COMPREHENSIVE OBJECTION TO AMENDED STATE SIGNIFICANT DEVELOPMENT APPLICATION

**SSD-83478456 — Residential Development with In-fill Affordable Housing
21, 23 and 25 McIntosh Street and 55 Werona Avenue, Gordon**

Date: 9 June 2026

Submitter: Owner of 12 Forsyth Street, Killara/Gordon (this submission updates earlier submission ref: SUB-92392706).

Drawing Title STORMWATER MANAGEMENT PLAN - GROUND SHEET No. 1					
Drawn	Date	Scale	A1	Q.A. Check	Date
IK	MAY 2025	AS SHOWN	A1	BK	21.05.2025
Designed	Project No.	Dwg. No.	Issue		
BK	CC250085	C5	A

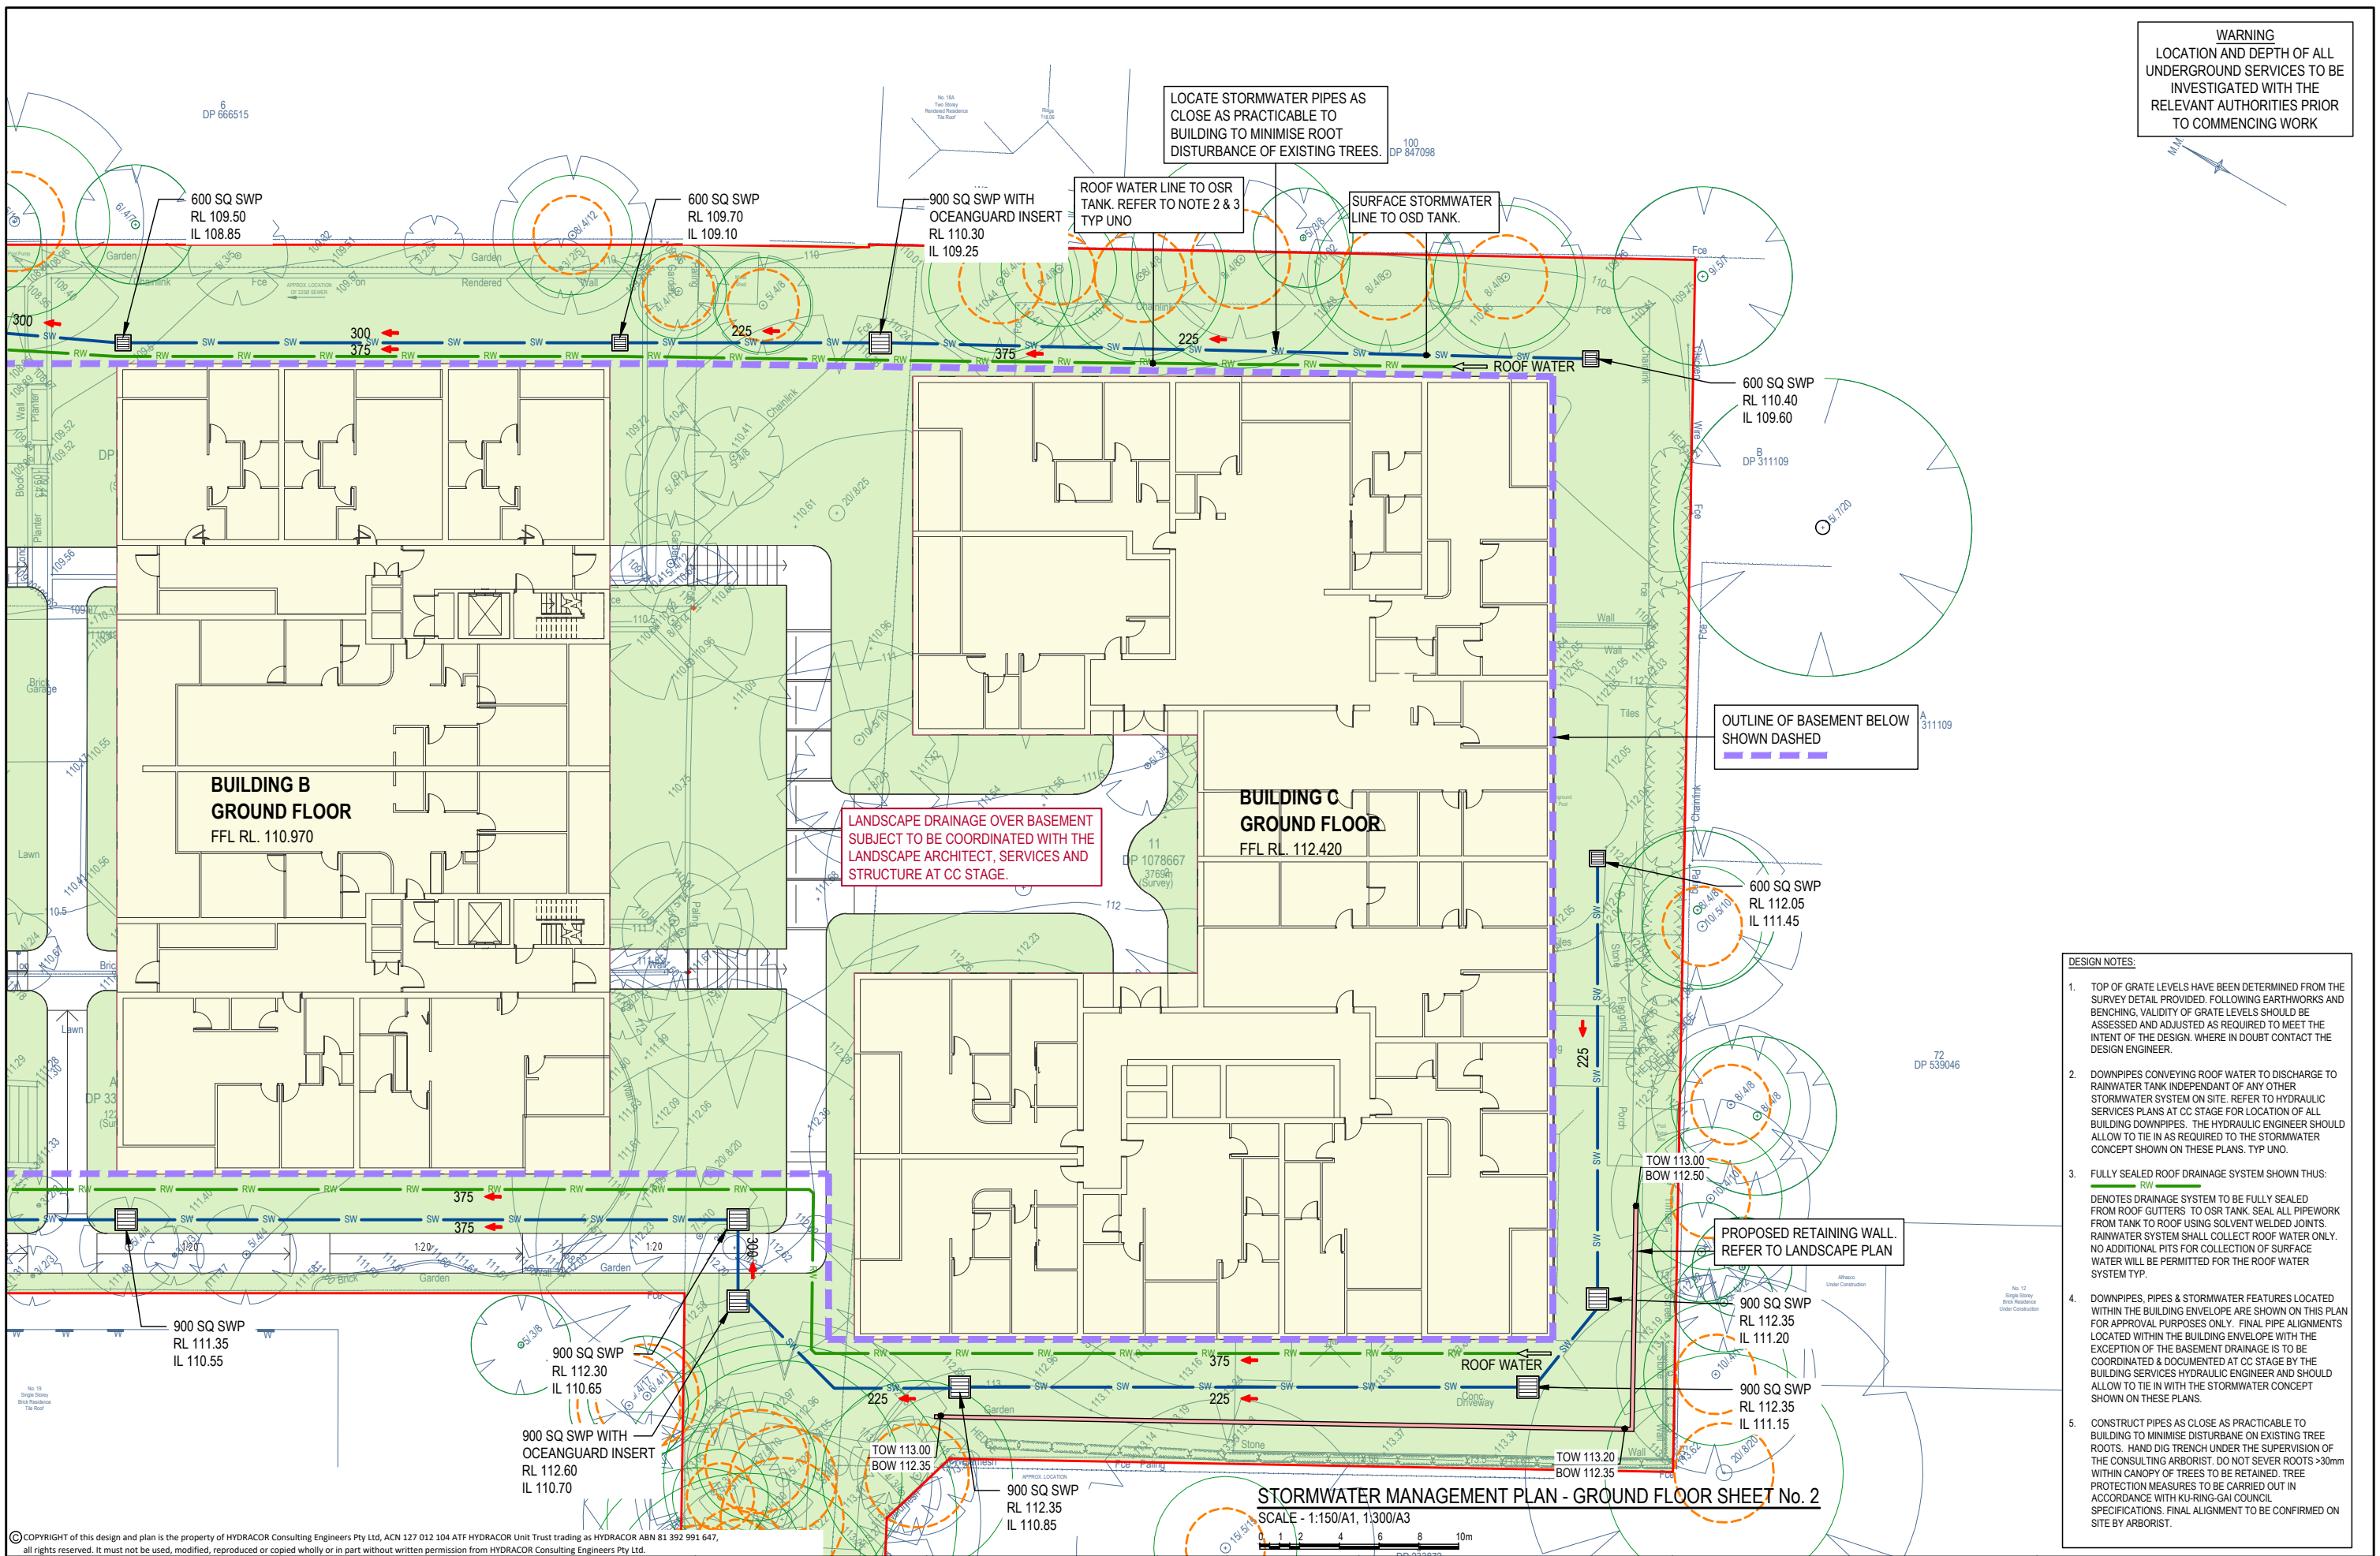
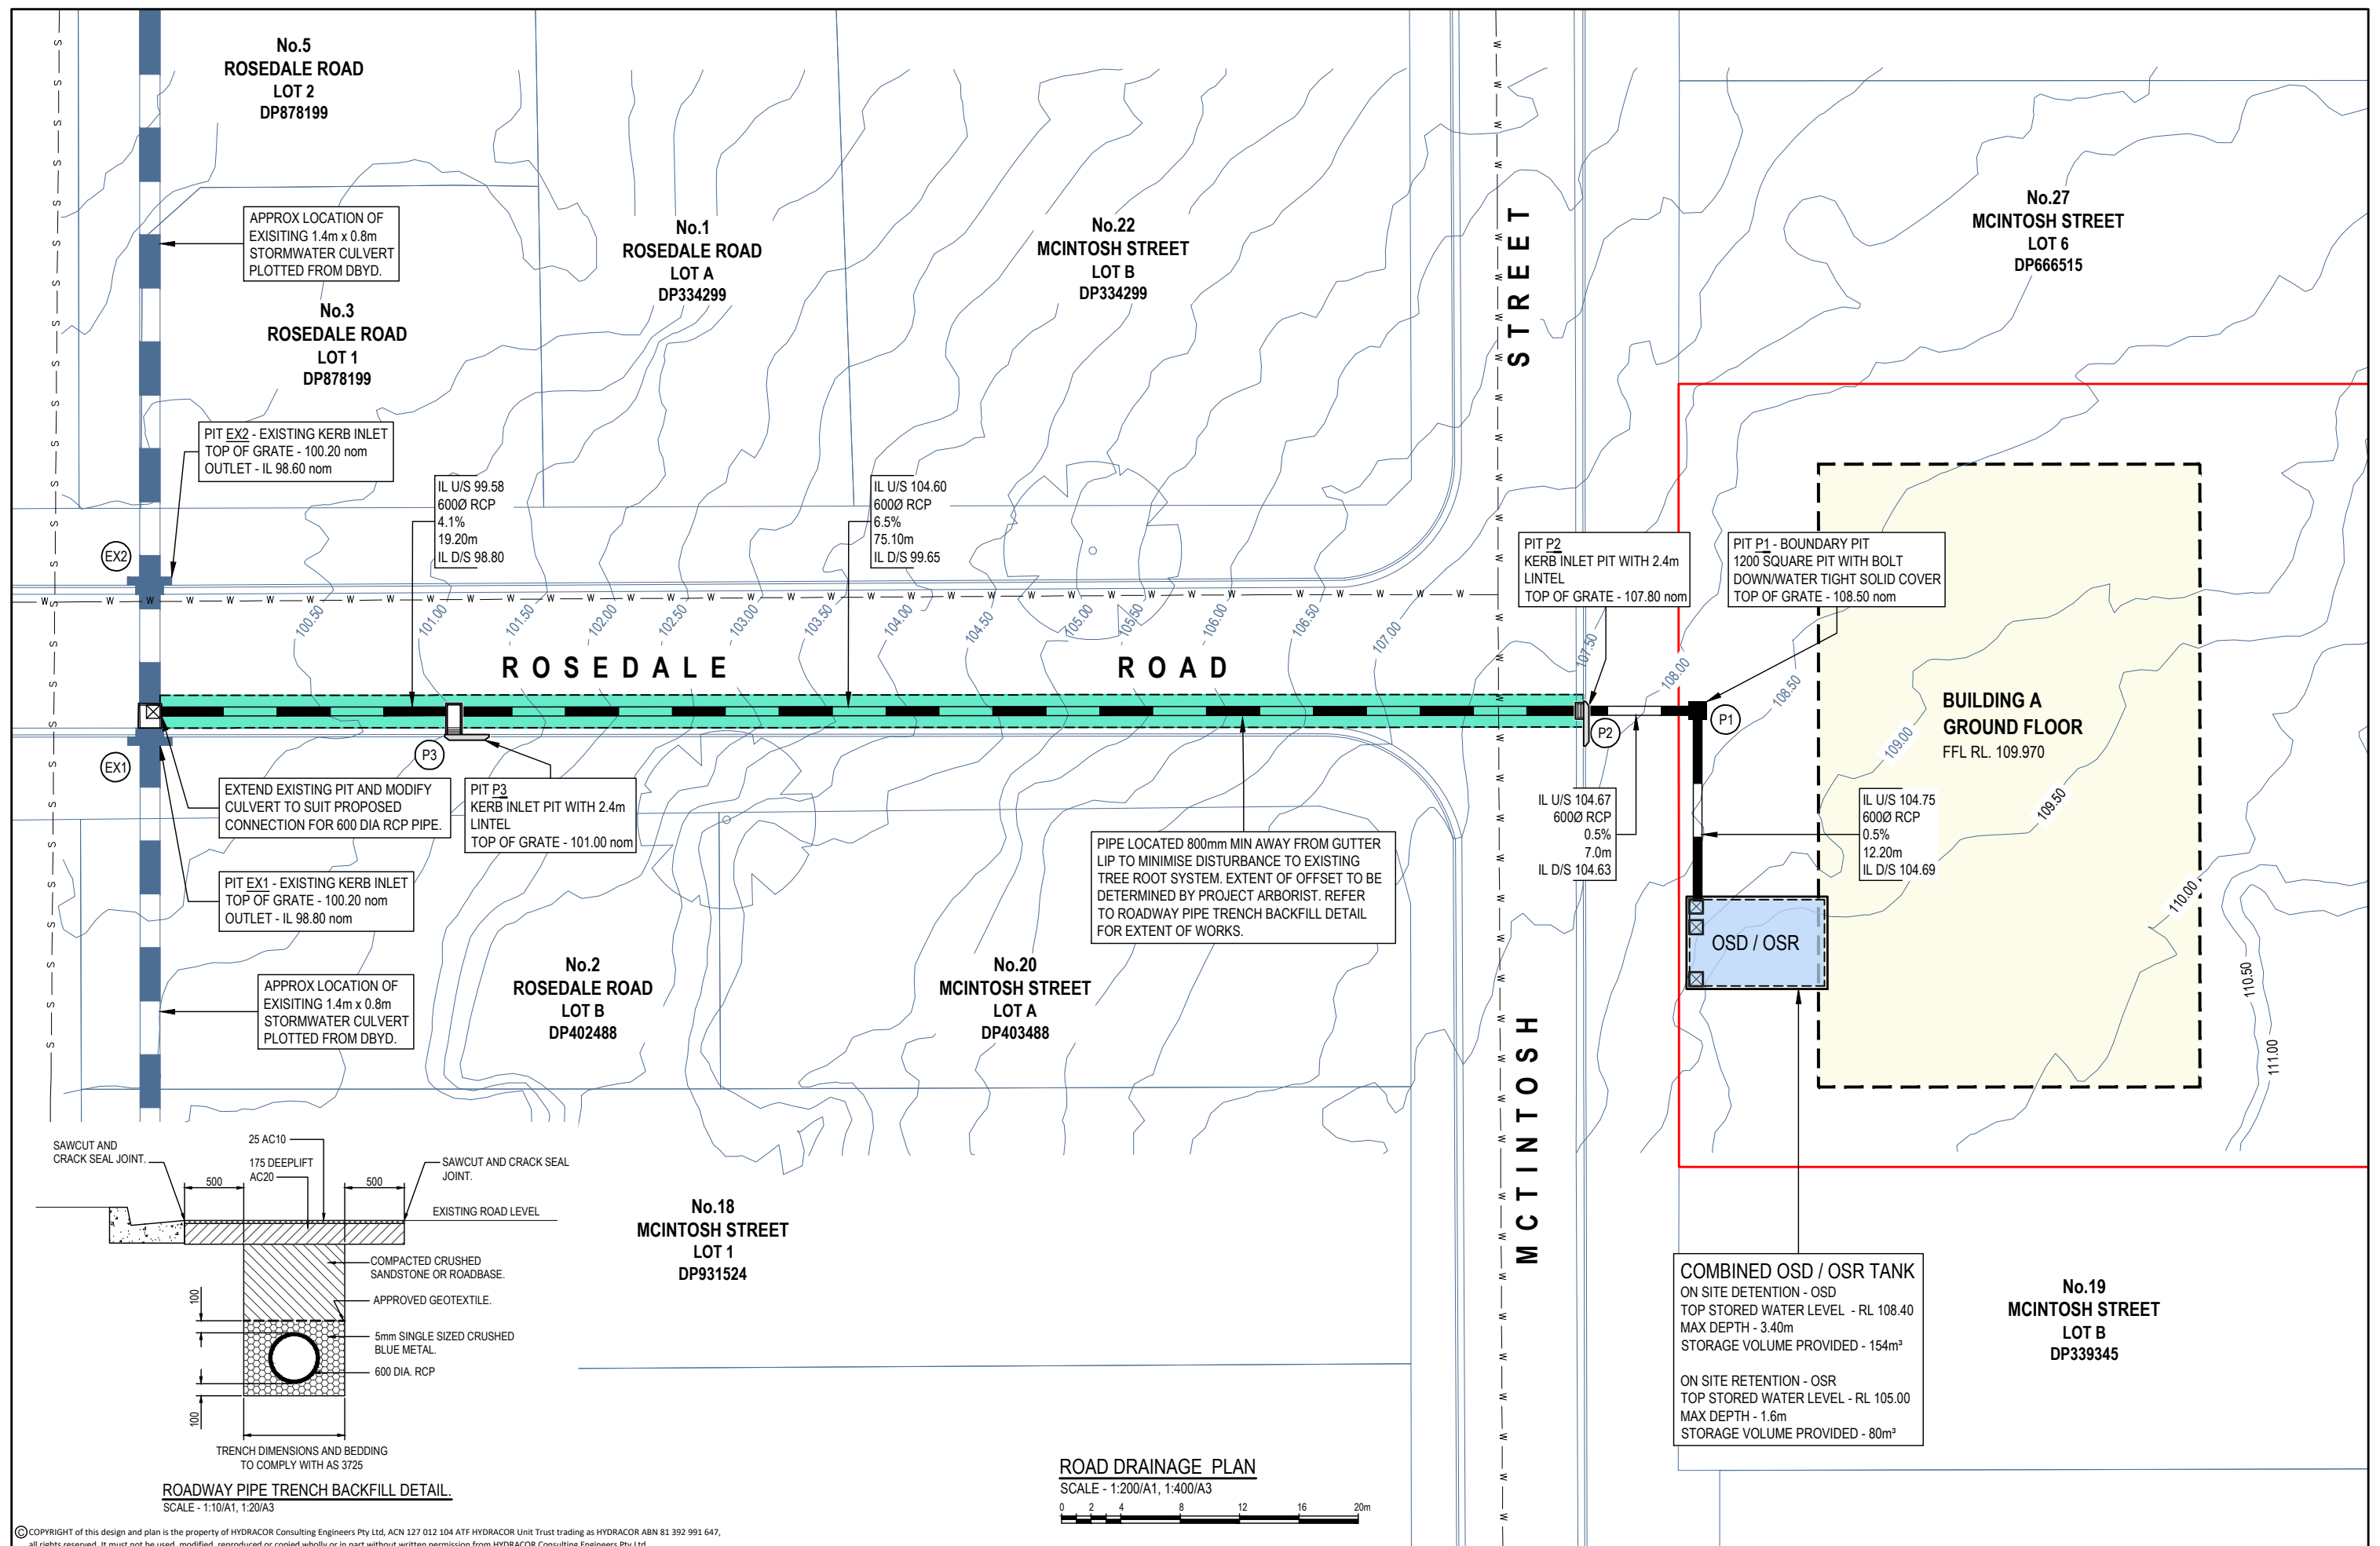
Stormwater documents defer important design matters. Appendix P still identifies 12 Forsyth as a single-storey brick residence under construction, despite the amended architectural plans identifying it as two-storey, and defers landscape and subsoil drainage to later coordination, with pump-out volume subject to geotechnical advice. The Department should require an independent hydrogeological and geotechnical peer review before determination or as a deferred-commencement condition, including a 12 Forsyth-specific settlement, groundwater, seepage and drainage risk assessment, monitoring bores along the southern boundary, transparent reporting, water-treatment requirements and stop-work triggers.
